Rezoning Transportation Analysis

Petition Number: 2020-178

General Location Identifier: Tax ID 08108503

Revision Log:

### REZONING PETITION #2020-178

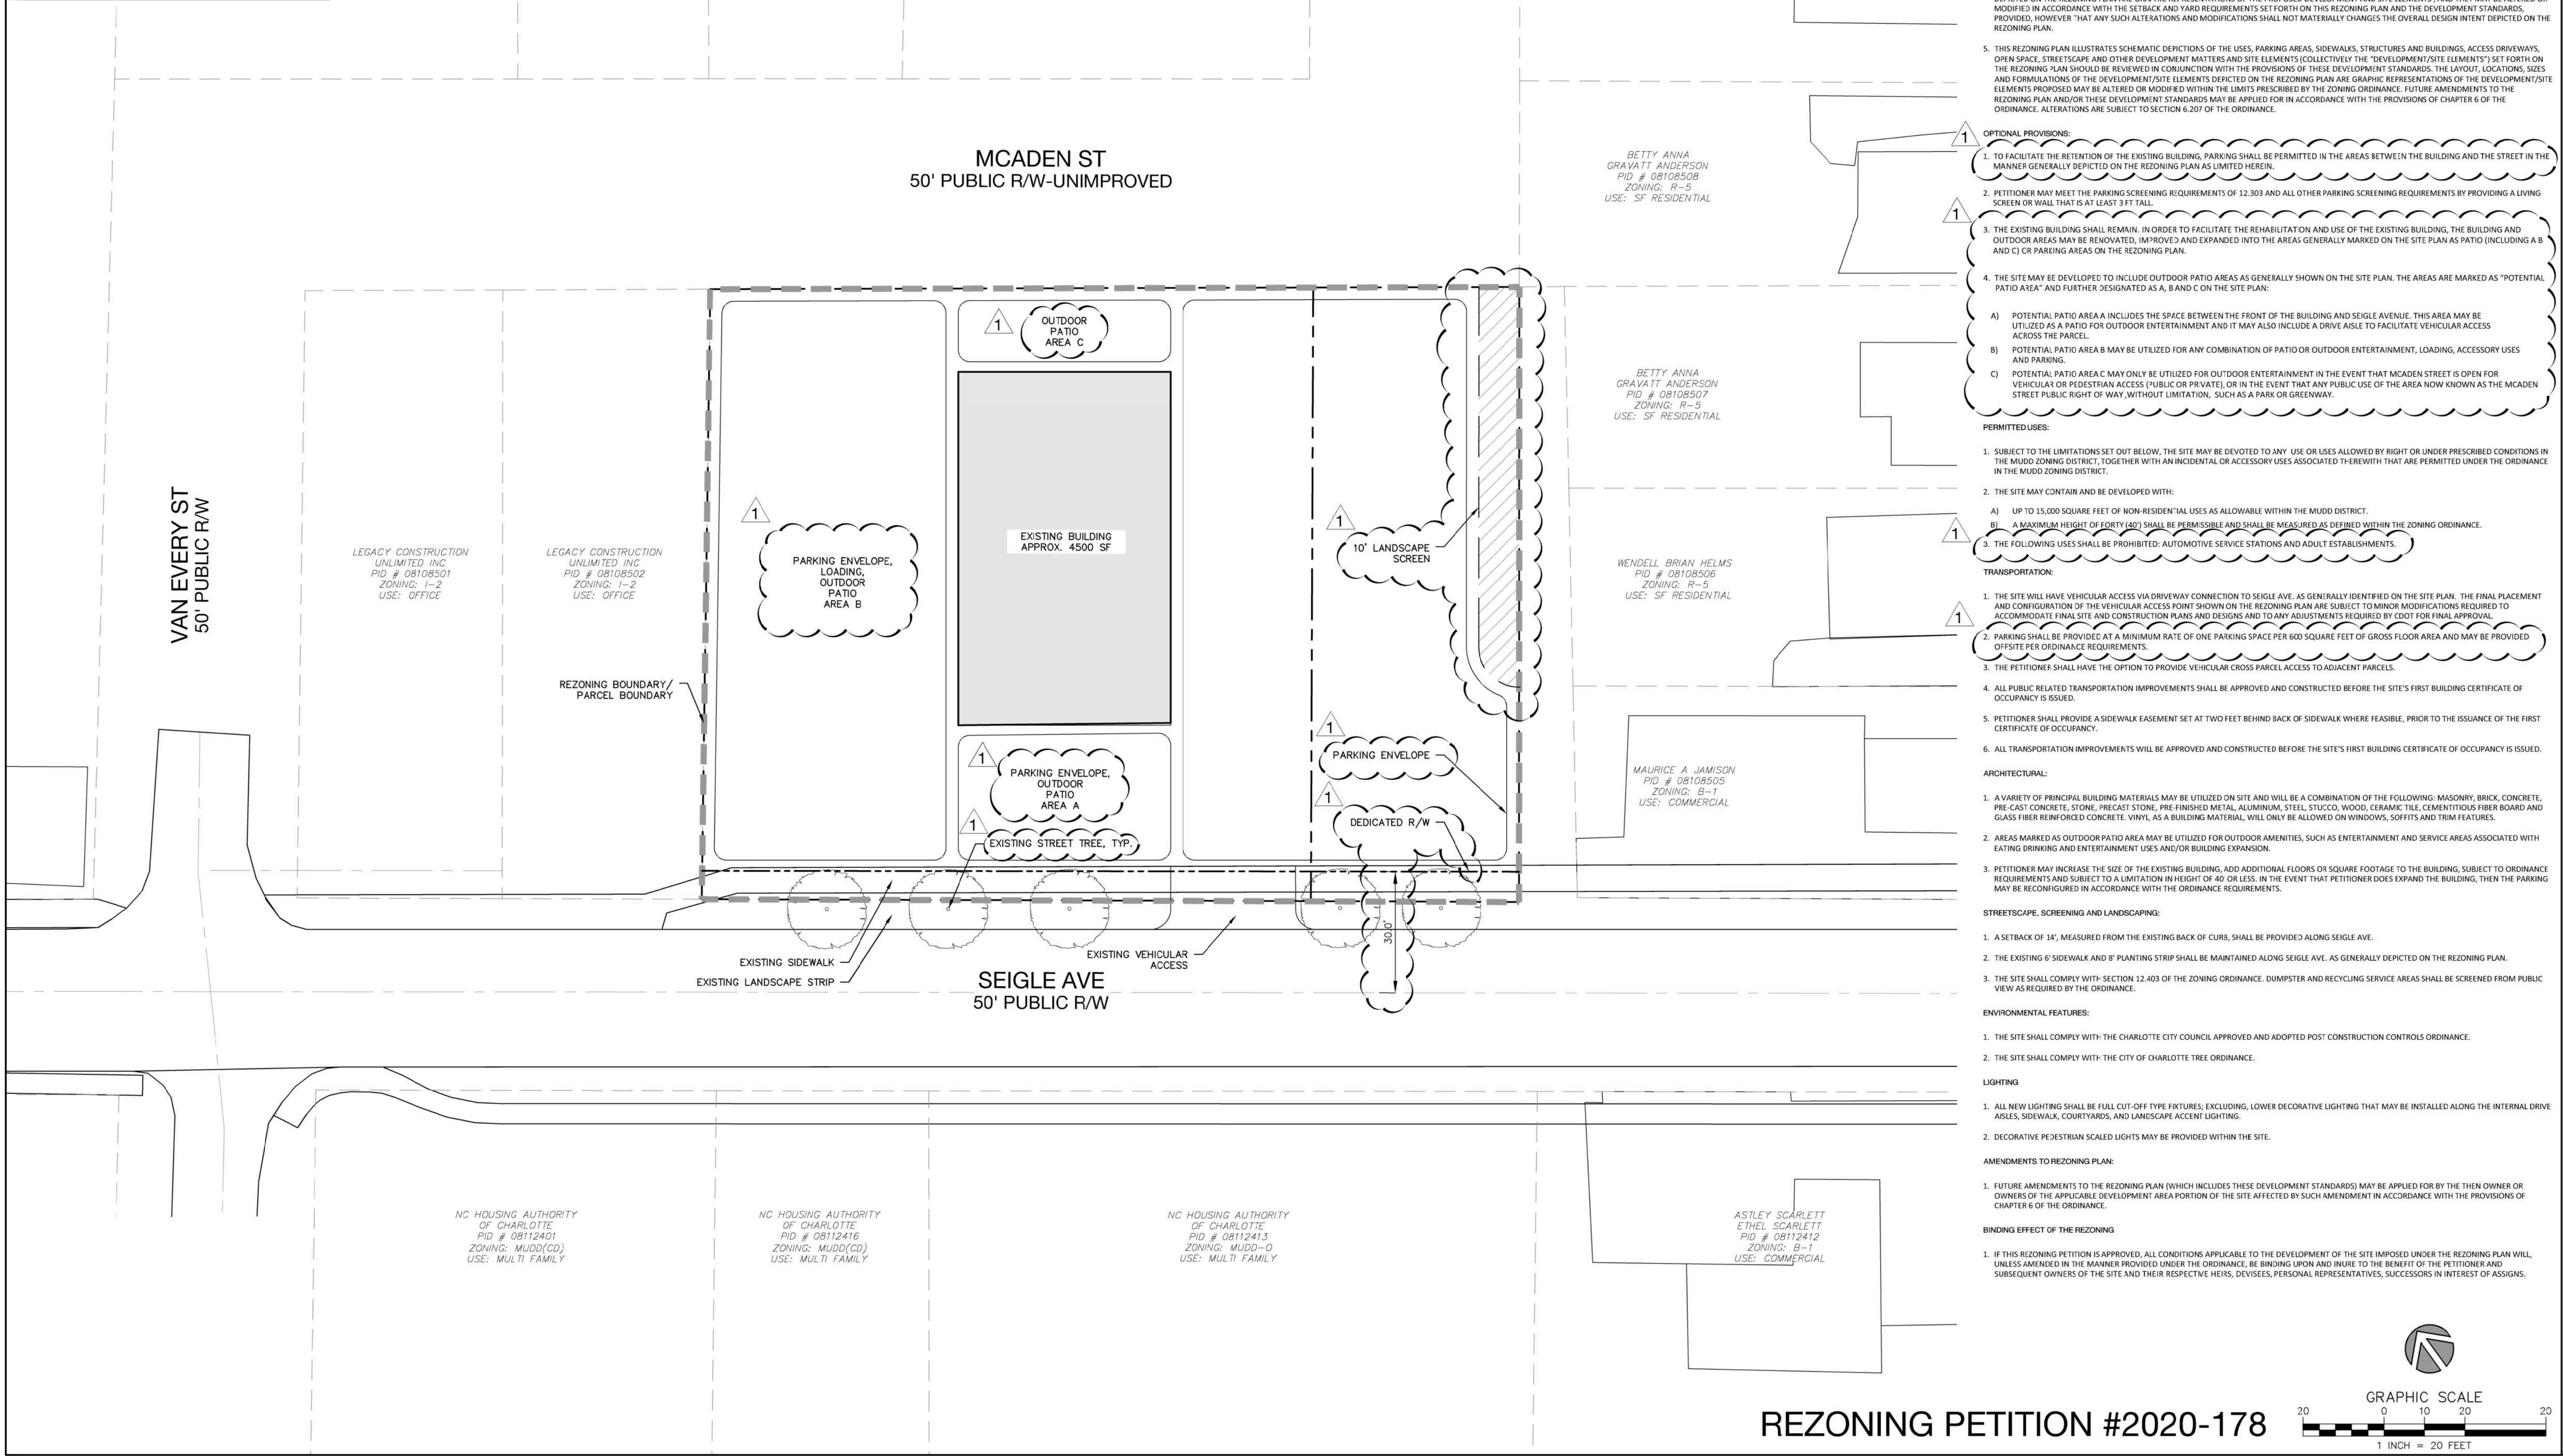
1. ~~**Curbline:** The proposed zoning district has a setback measured from back of the existing or proposed future curbline.
 - a. ~~**Seigle Avenue:** The future location of curb and gutter is in its existing location.

Label and dimension the curb and gutter from the centerline on the site plan.~~~~

3. ~~Revise site plan and conditional note(s) to commit to dedicating 30-foot right-of-way from the Seigle Avenue centerline. Label and dimension the right-of-way from the road centerline.~~
